New House lot

Permit # 2014-00163

CHECK-LIST AGAINST ZONING ORDINANCE

revised site plan 5/12/14

SITE PLAN

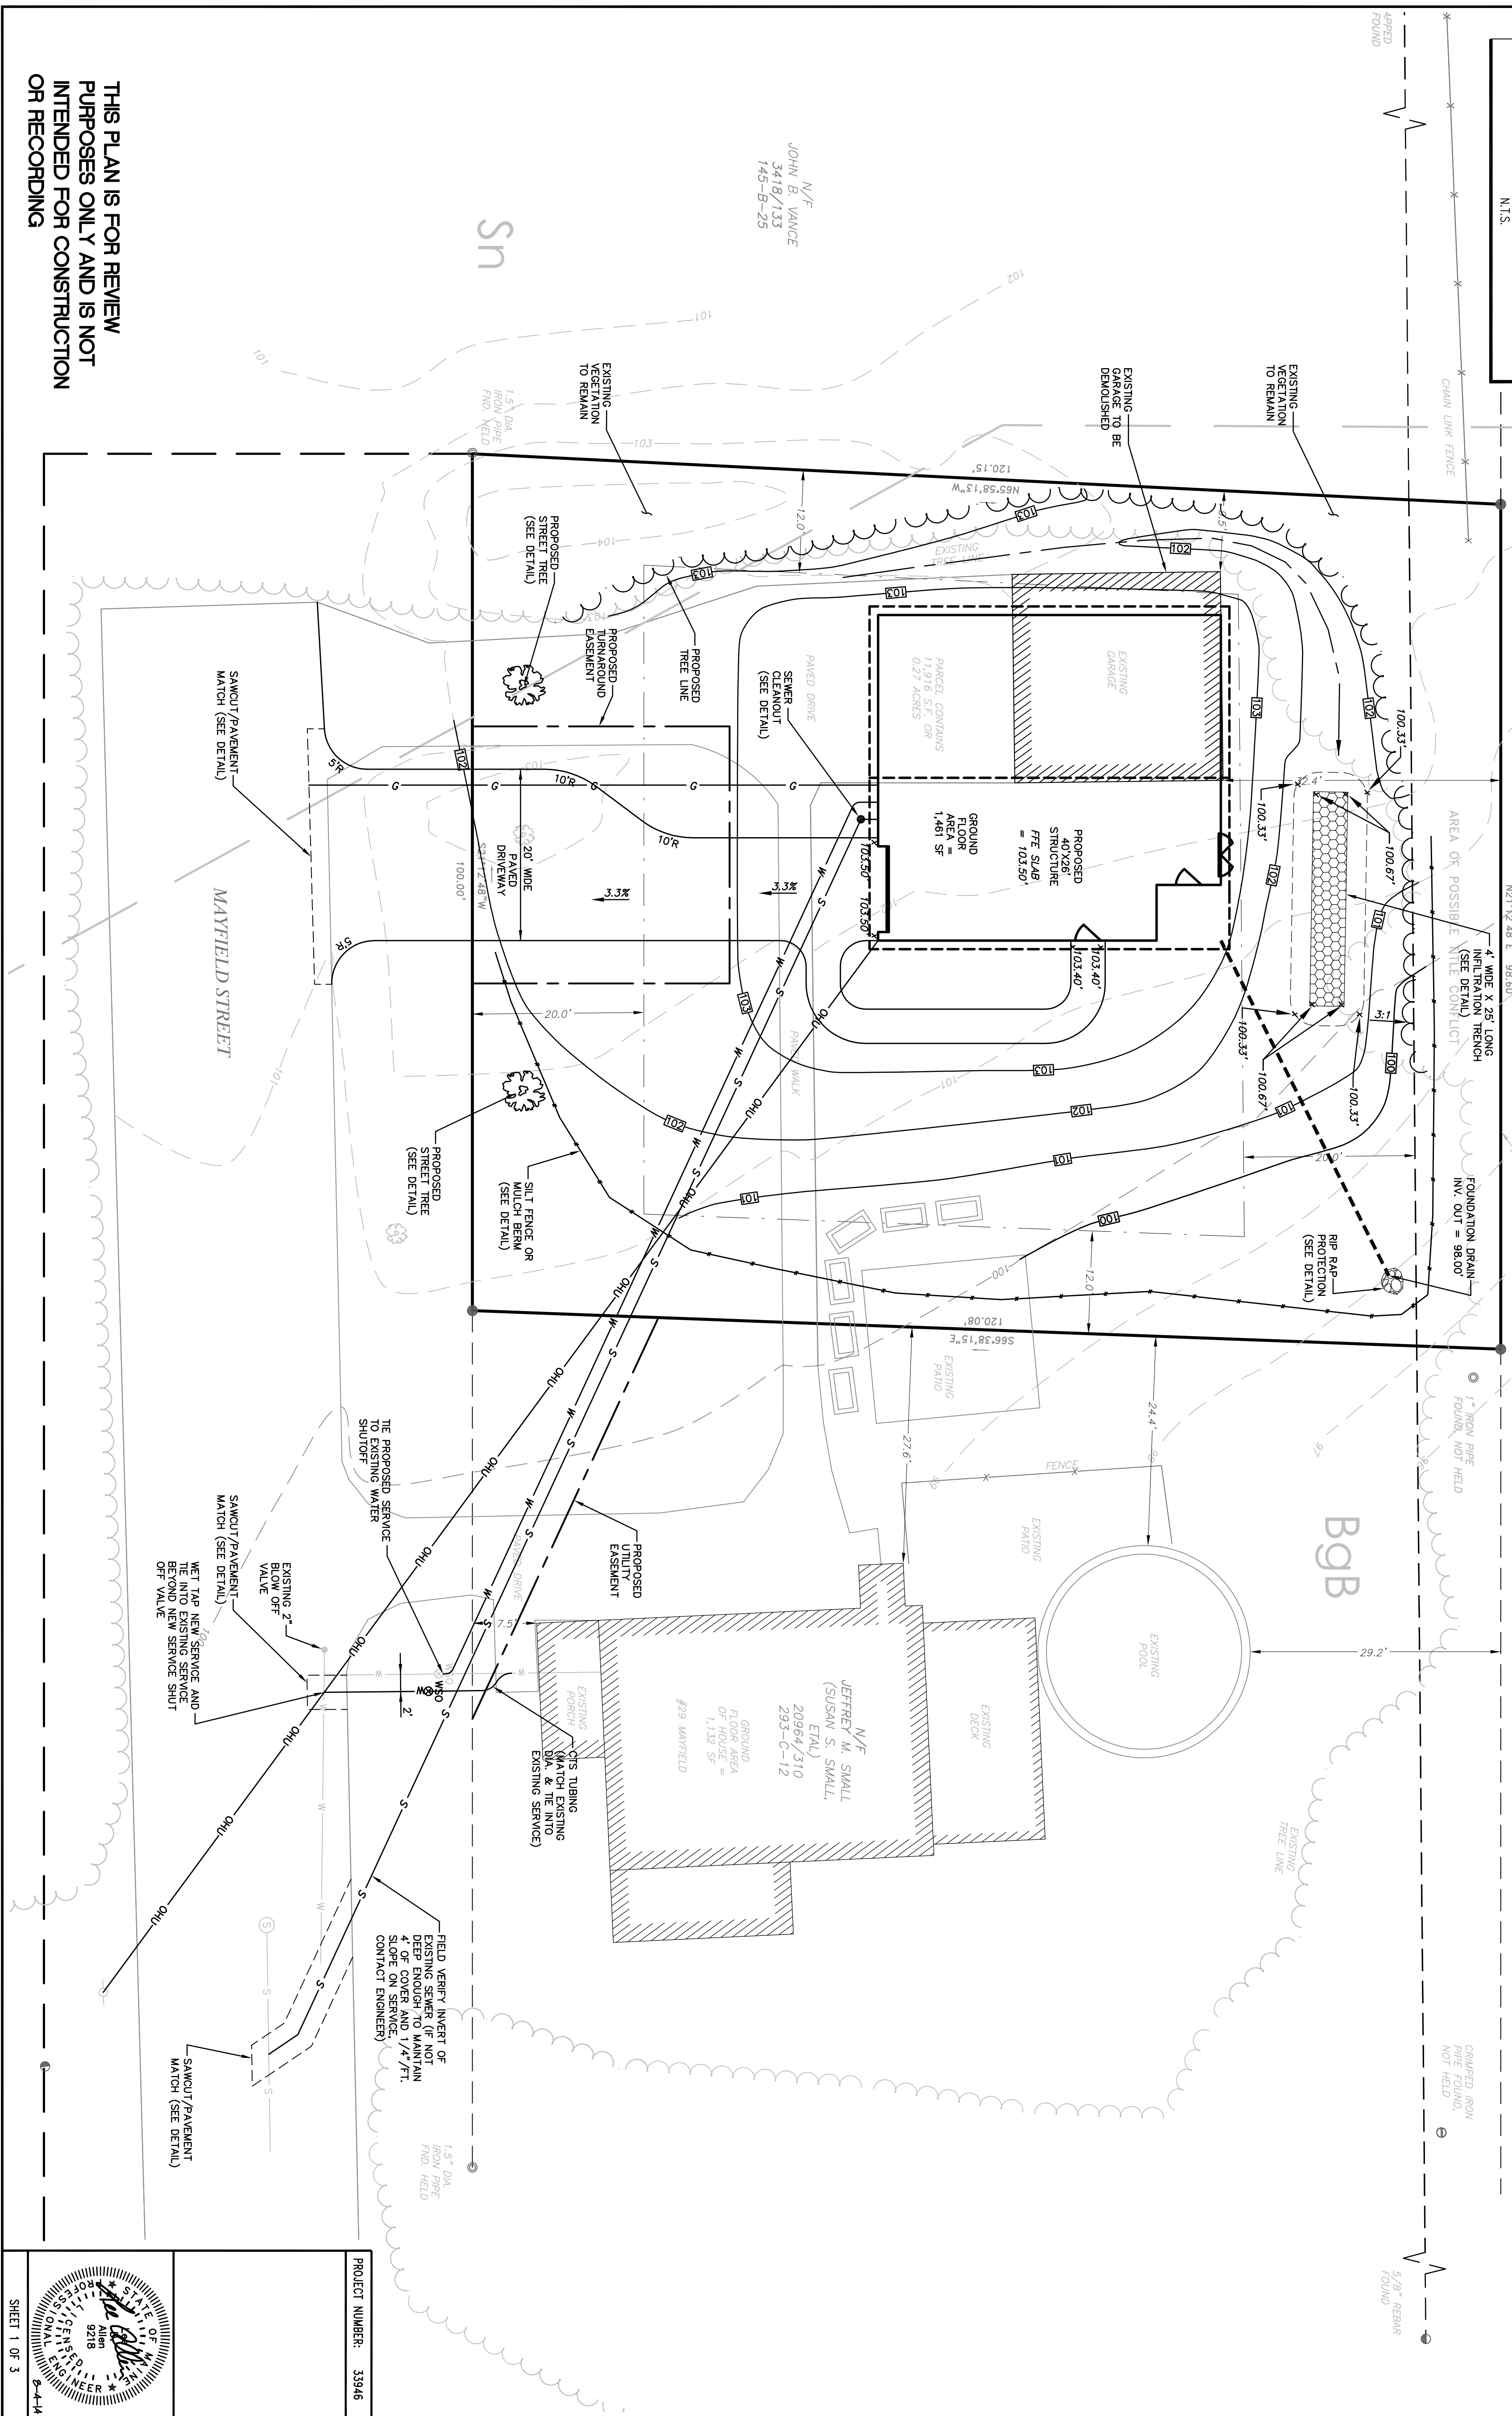
Front Yard - ~~50' min.~~ 20' min. - 22.8' scaled (OK)

Rear Yard - 20' min. - 47.6' scaled to "max possible" like offset.

Side Yard - 1 or 1 1/2 story - 8' min. 15.7' min left (OK)
2 stories - 12' min. 44.72' on right
45.4' "

Width of Lot - 60' min. - 98.3' scaled (OK)

Height - 35' max. - 20' scaled from grade to ridge (OK)

Lot Area - 6,500 sq ft min - 11,916 sq ft (OK)

Lot Coverage/Impervious Surface - 40% = 4764 sq ft

Off-street Parking - 2 parking spaces - one in garage, one parallel to road setback 20' (OK)

(shed) 10 x 12 = 120
31.5 x 40 = 1260
6.5 x 32.5 = 211.25
porch 6.5 x 7.5 = 48.75

7520
1640 (OK)
